From: Lisa Coney
Sent: 21 June 2017 12:29
To: [REDACTED]
Subject: FG/79/17/HH - 4 Ferring Marine

I am currently dealing with a compliance case relating to the above site, to which, I have invited the above application.

CLIENT. P. ALAYOINE ESQ, 4, FERRING MARINE, FERRING, W. SUSSEX BN12 5PP	date . January 2017 . scale . 1:100 and 1:50 .
DRAWING NUMBER 20117.1A of 2

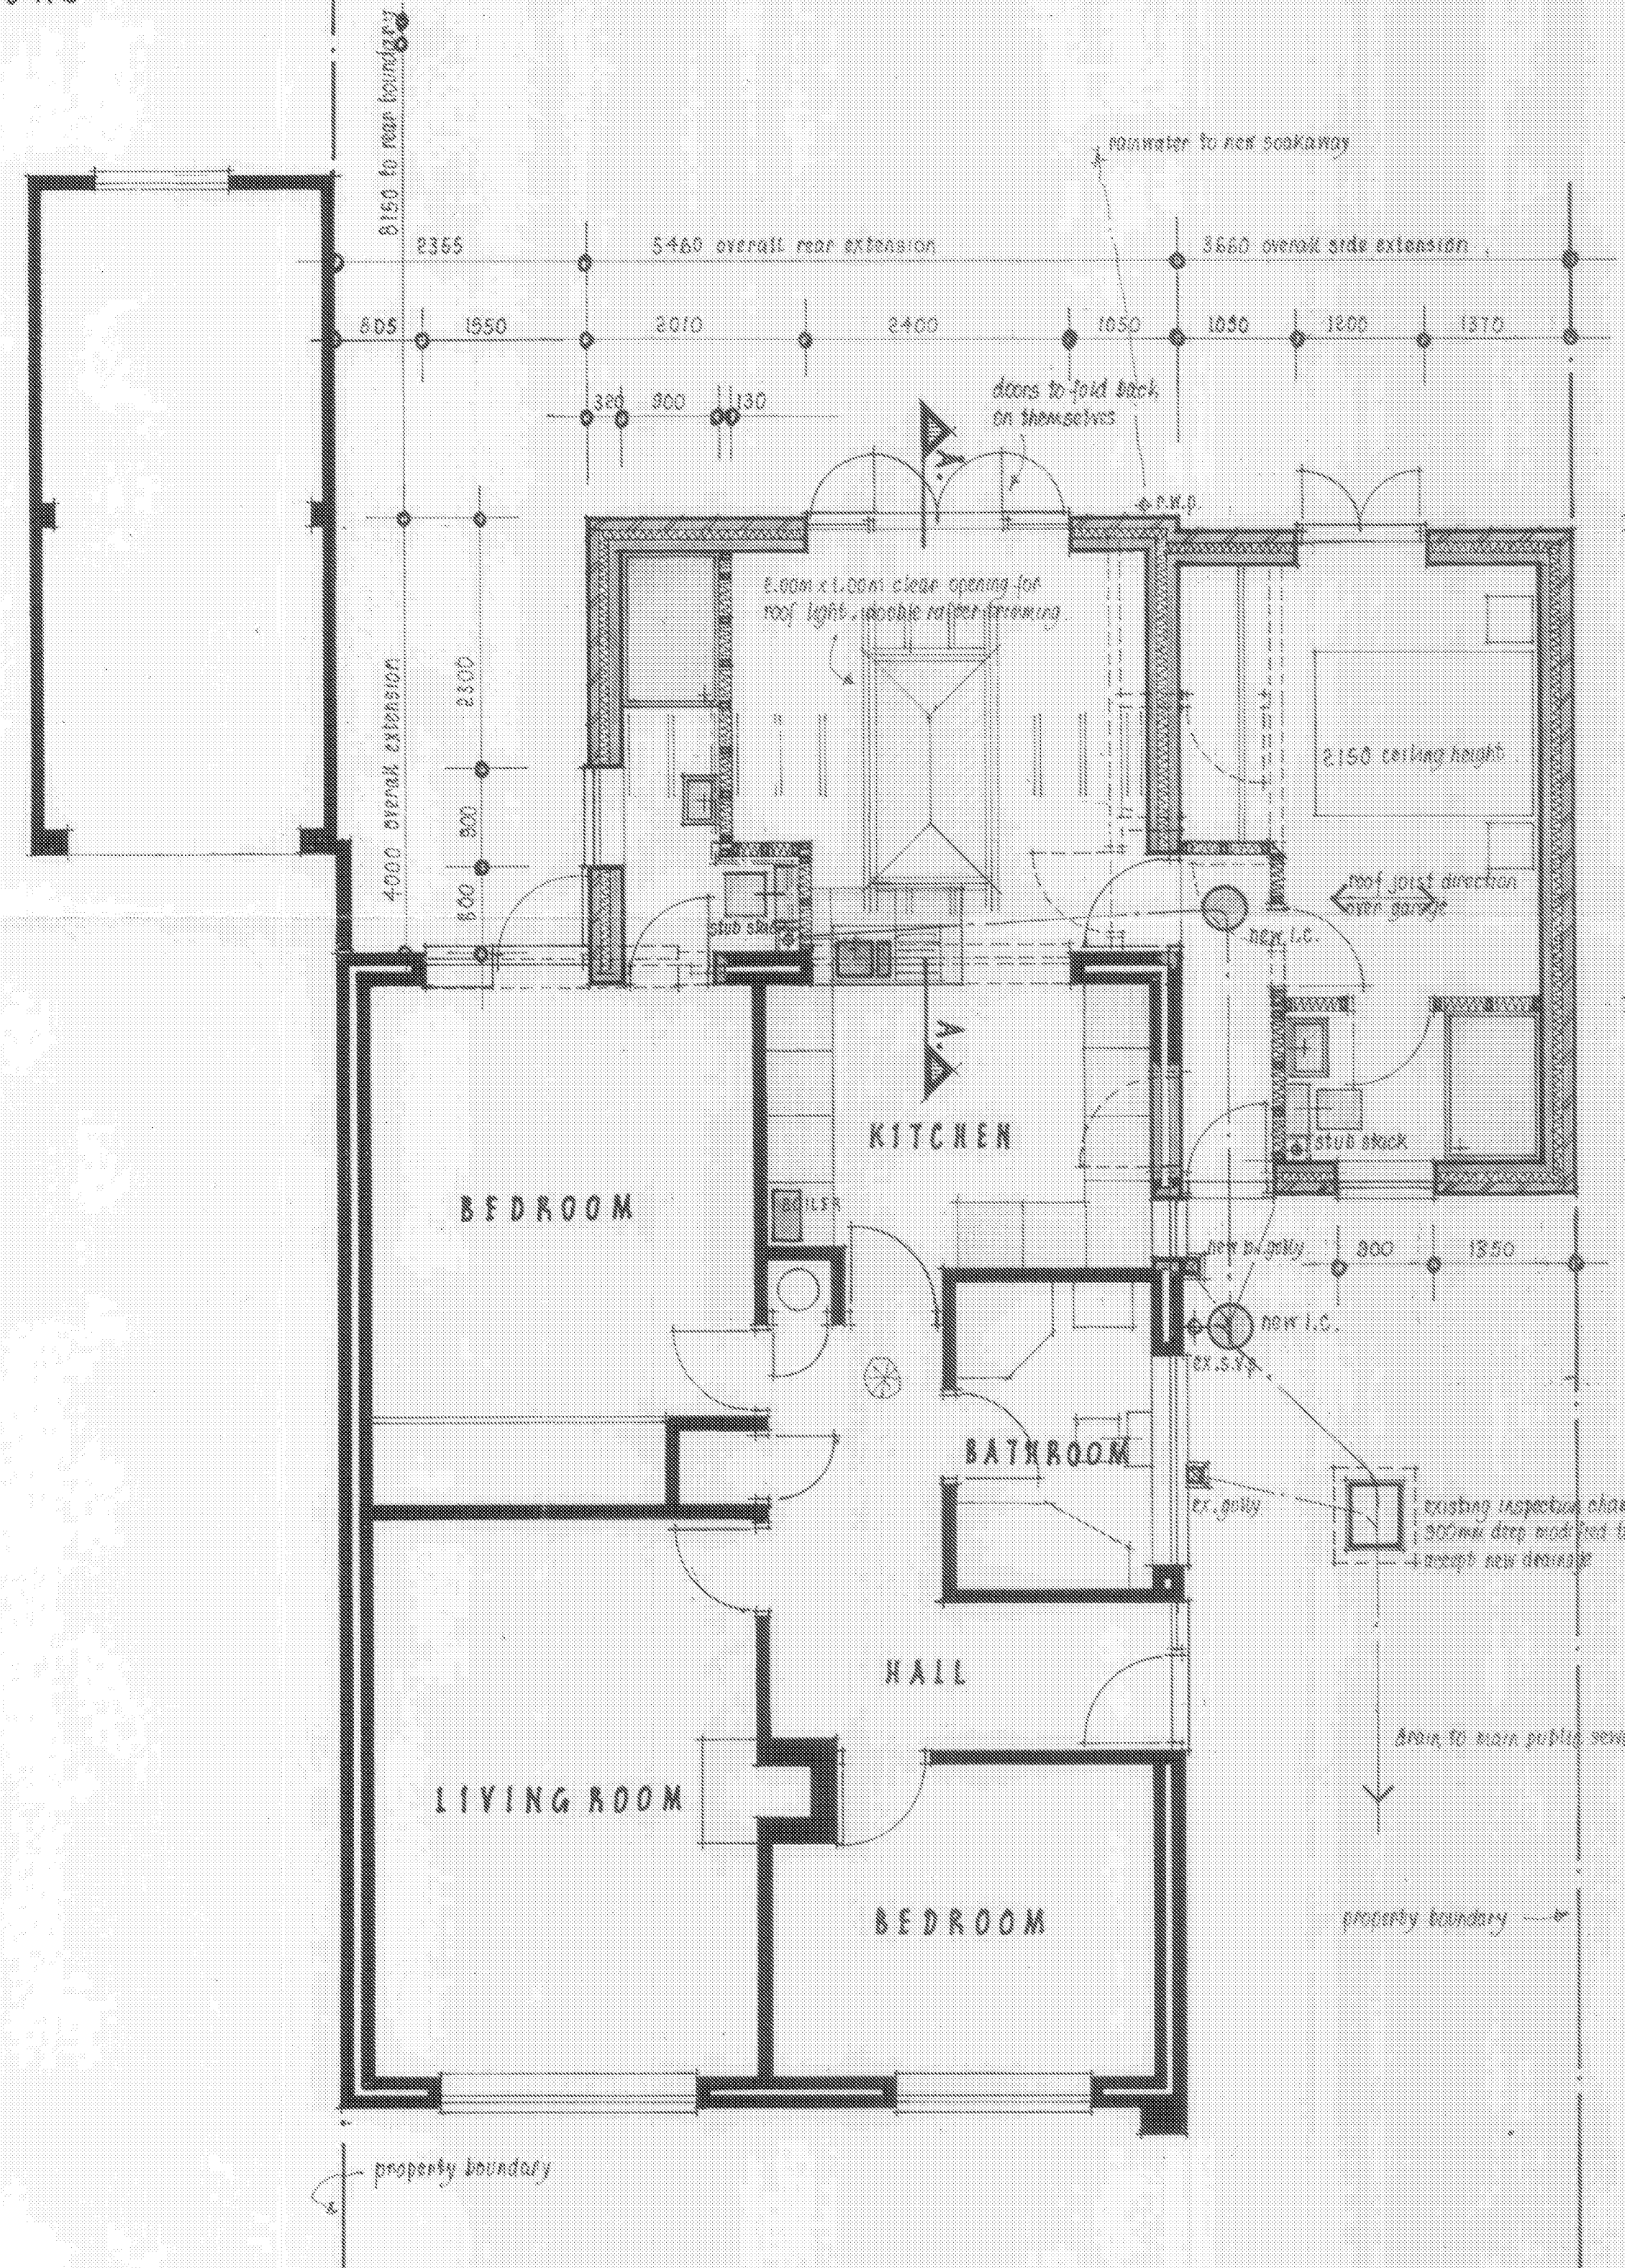
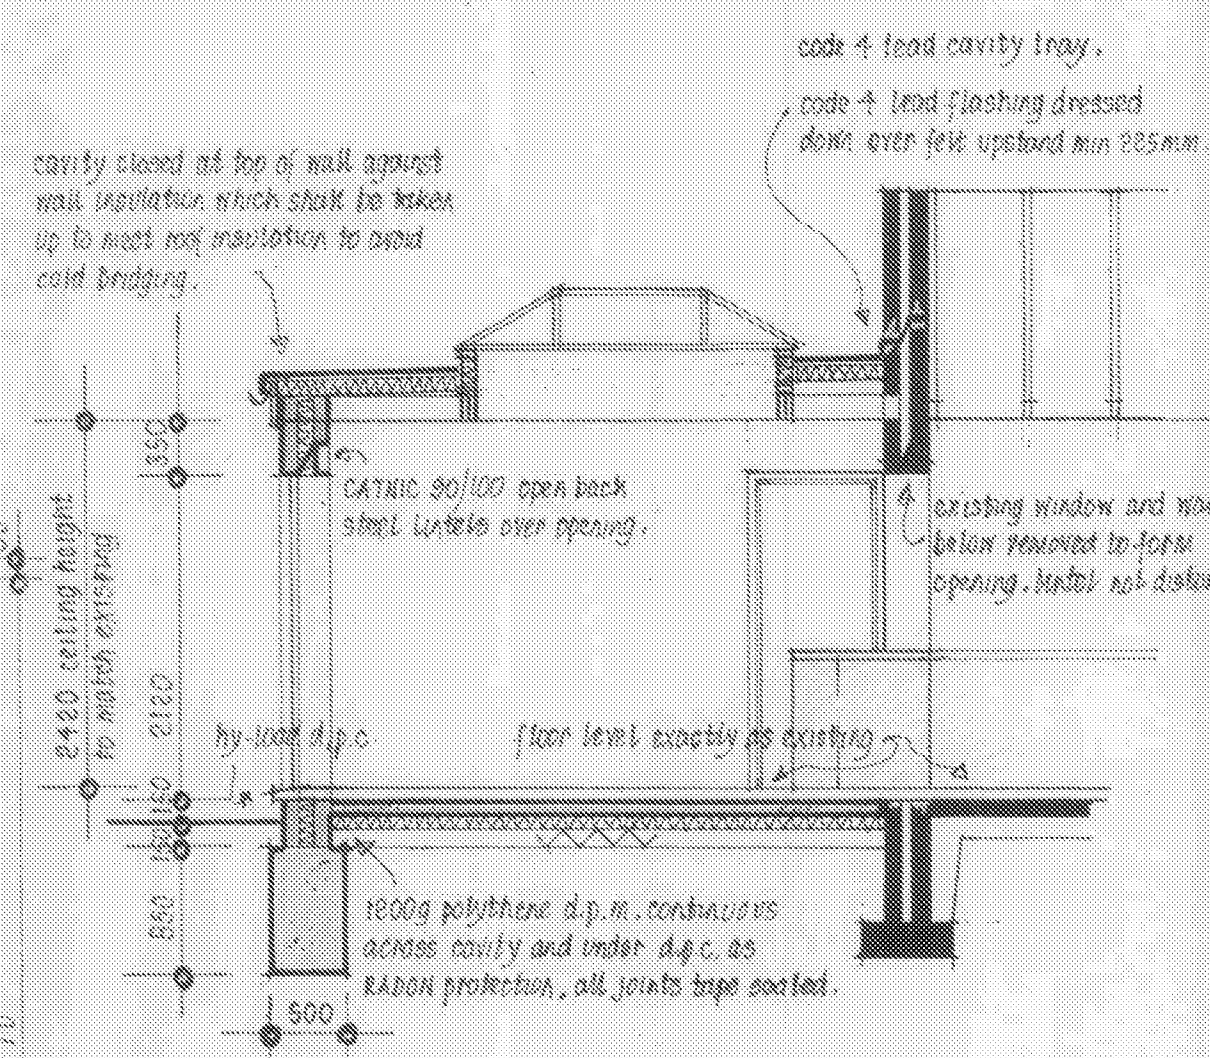
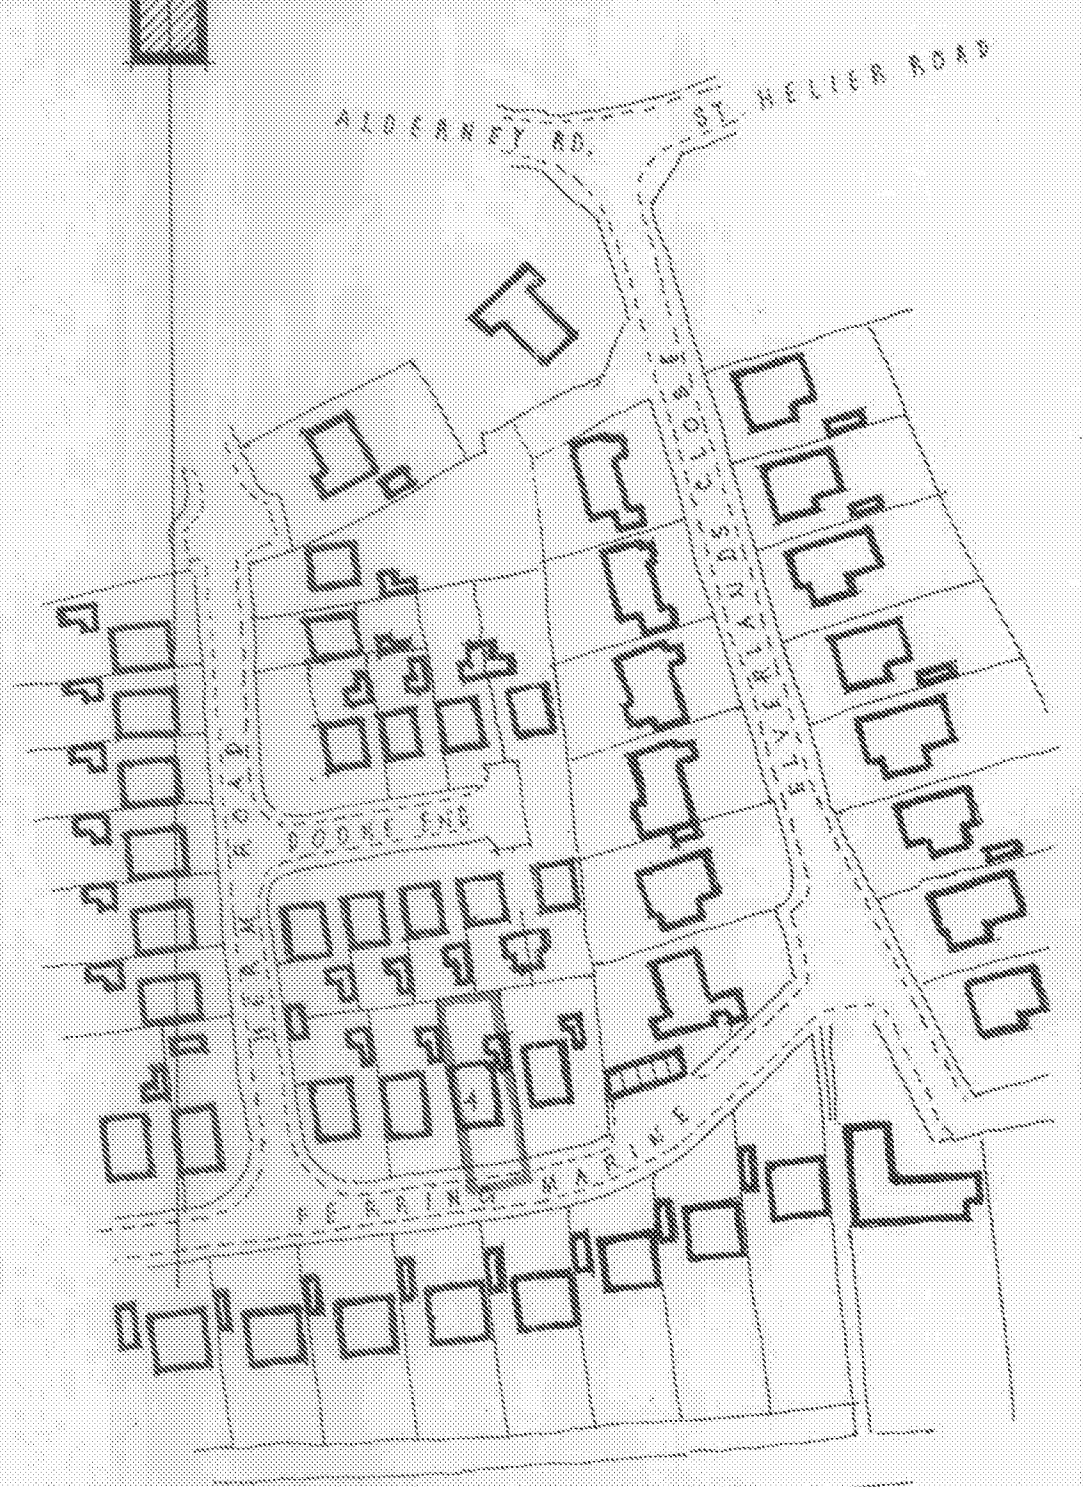
Following my site inspection, I can confirm that the existing garage has been demolished & not converted in accordance with Building Control requirements.

I note, the application is currently on hold and, that the plan submitted with the application shows conversion works & is dated January 2017.
